Conservation Area Advisory Committee

AL/60/15/HH

Demolition of existing rear extension & erection of a single storey rear extension within the Church Road, Aldingbourne Conservation Area.

14 Church Road
Aldingbourne

Proposed Plan and Elevations Scale: 1:50

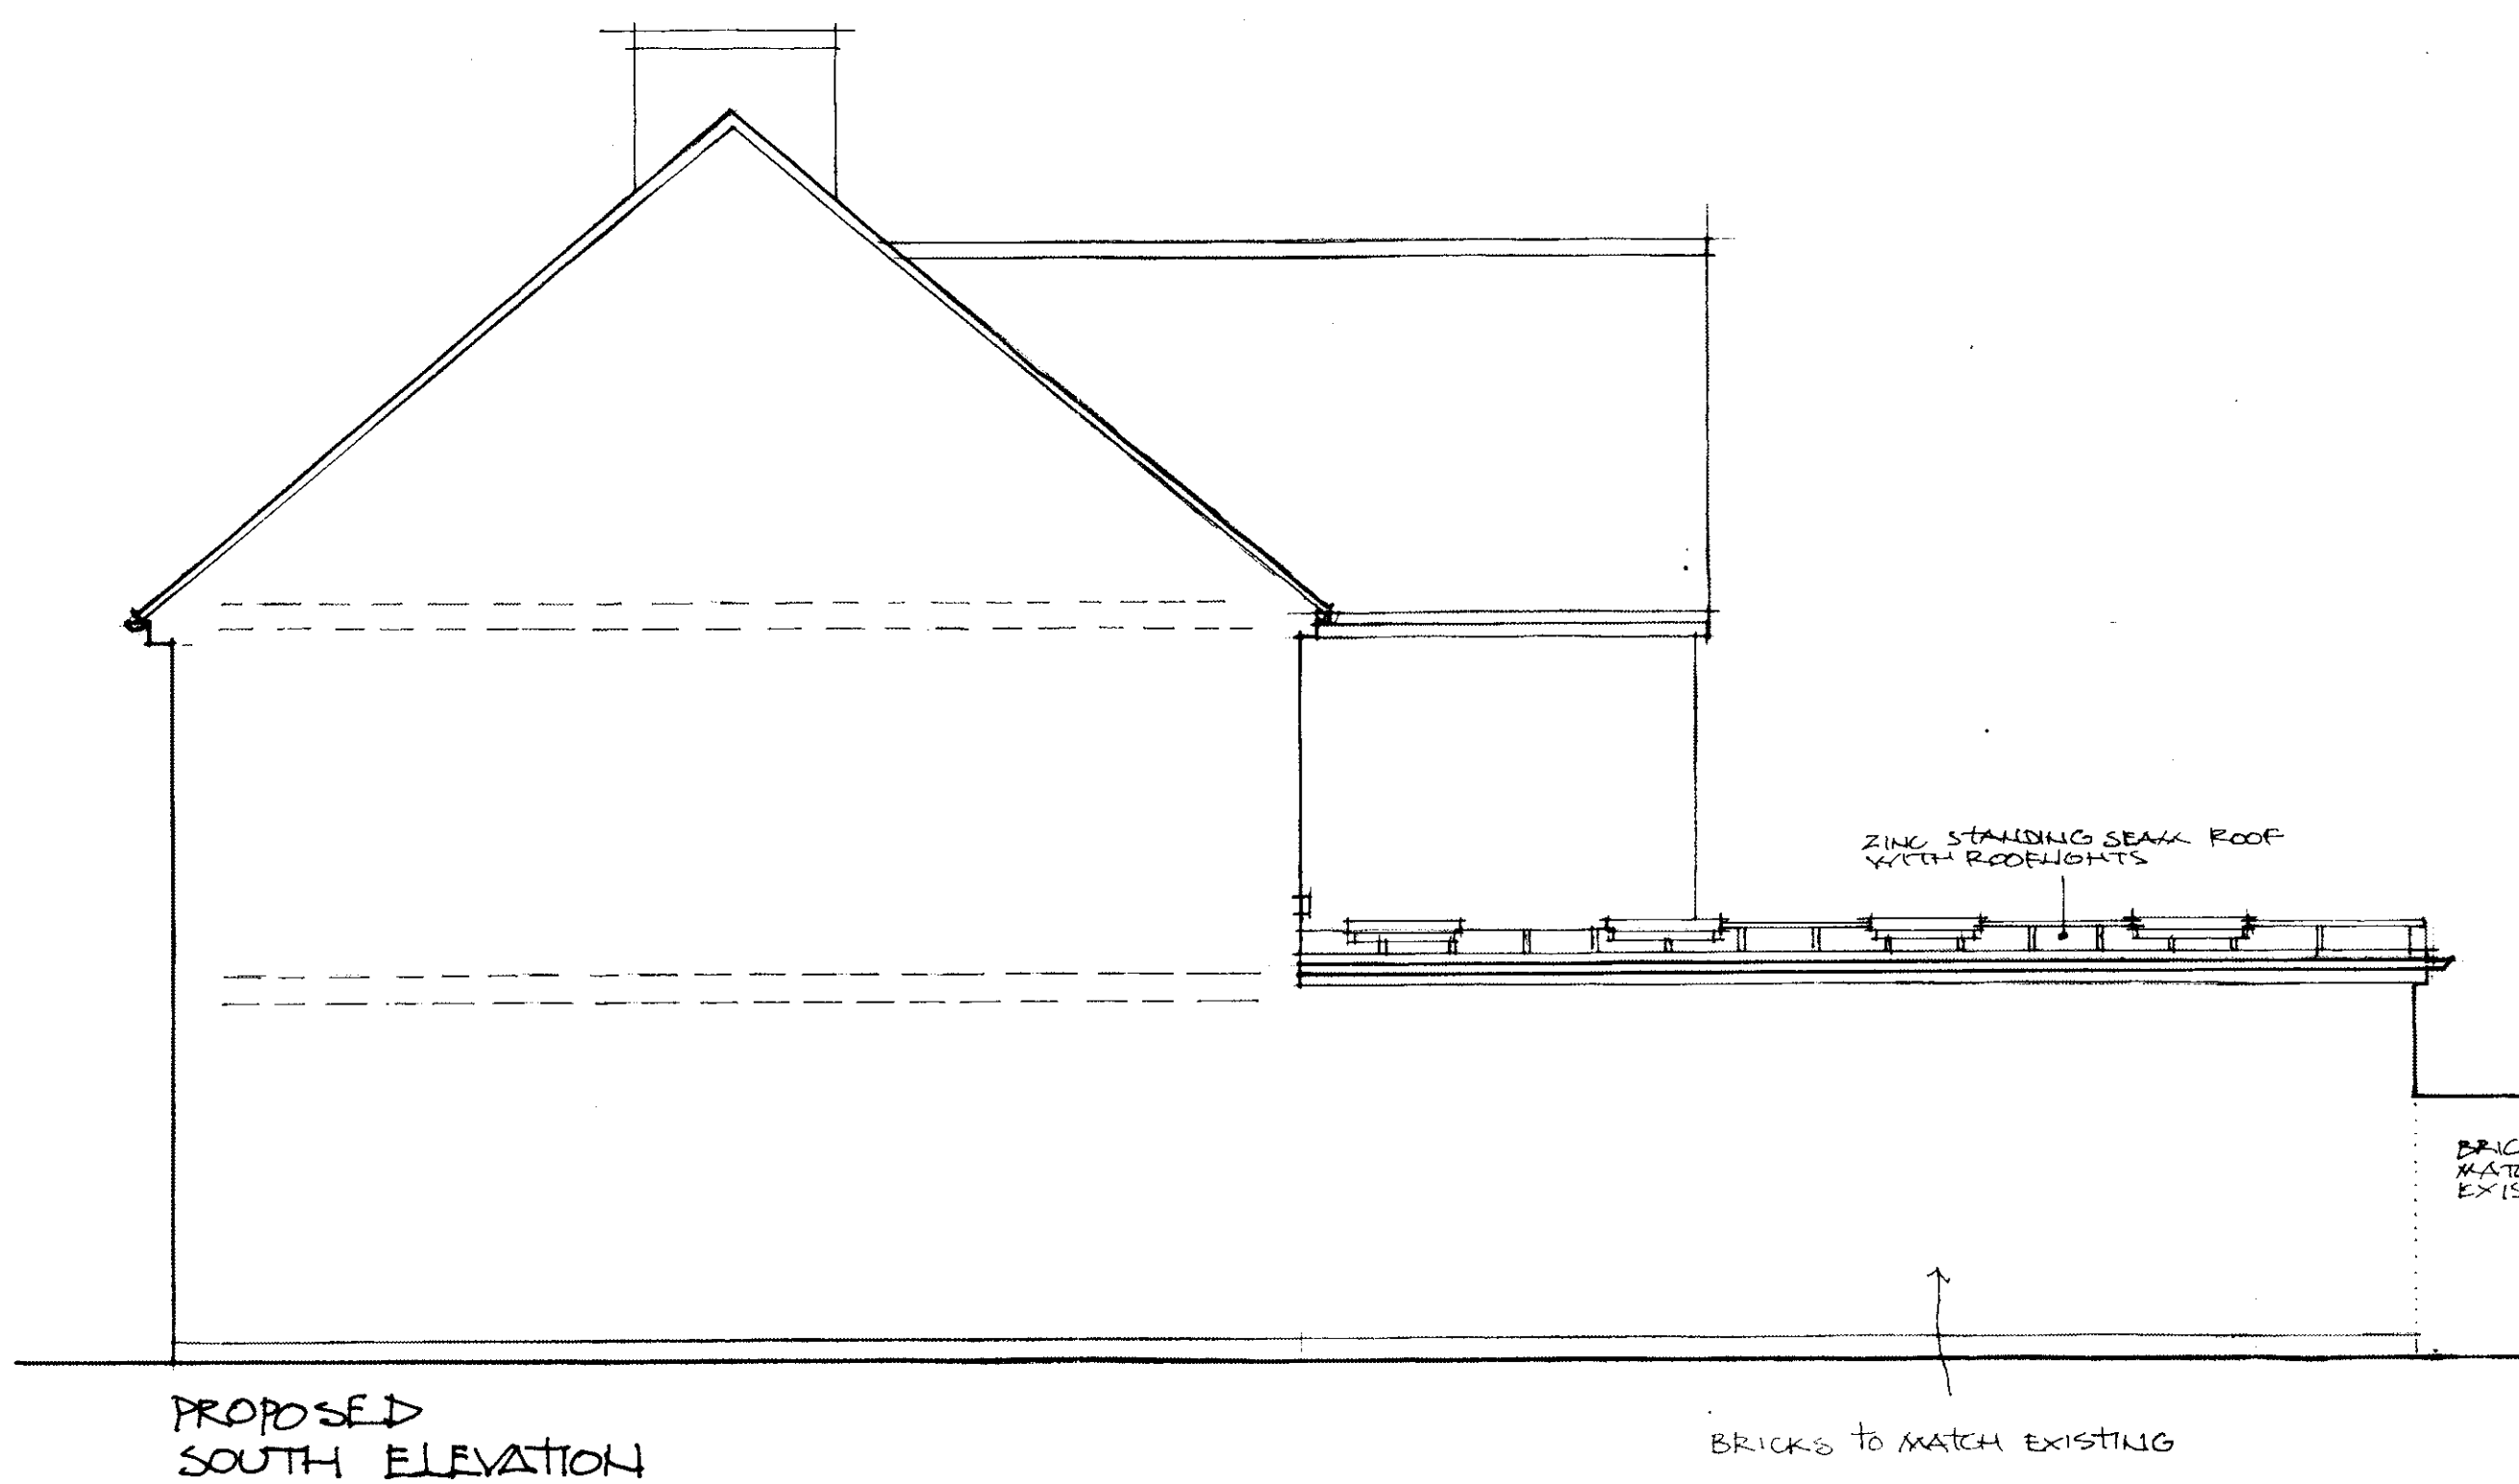
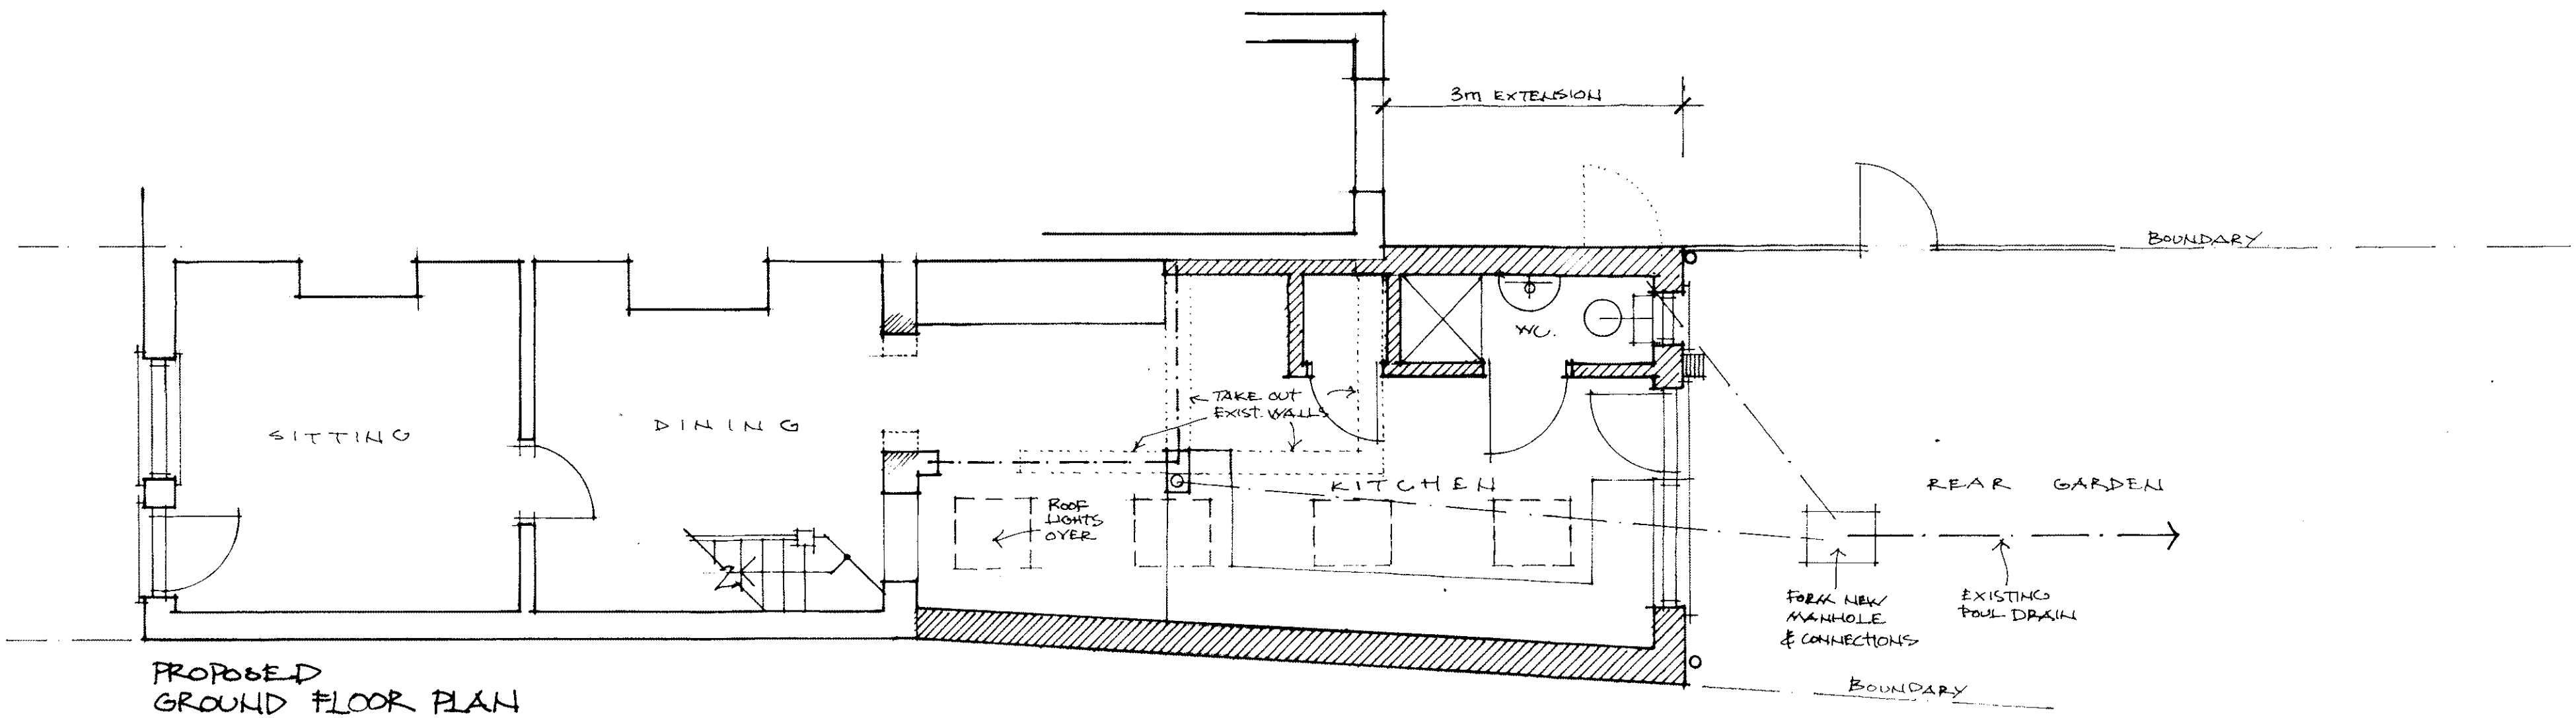
We believe the window design could be much improved by being multi-paned as the first floor
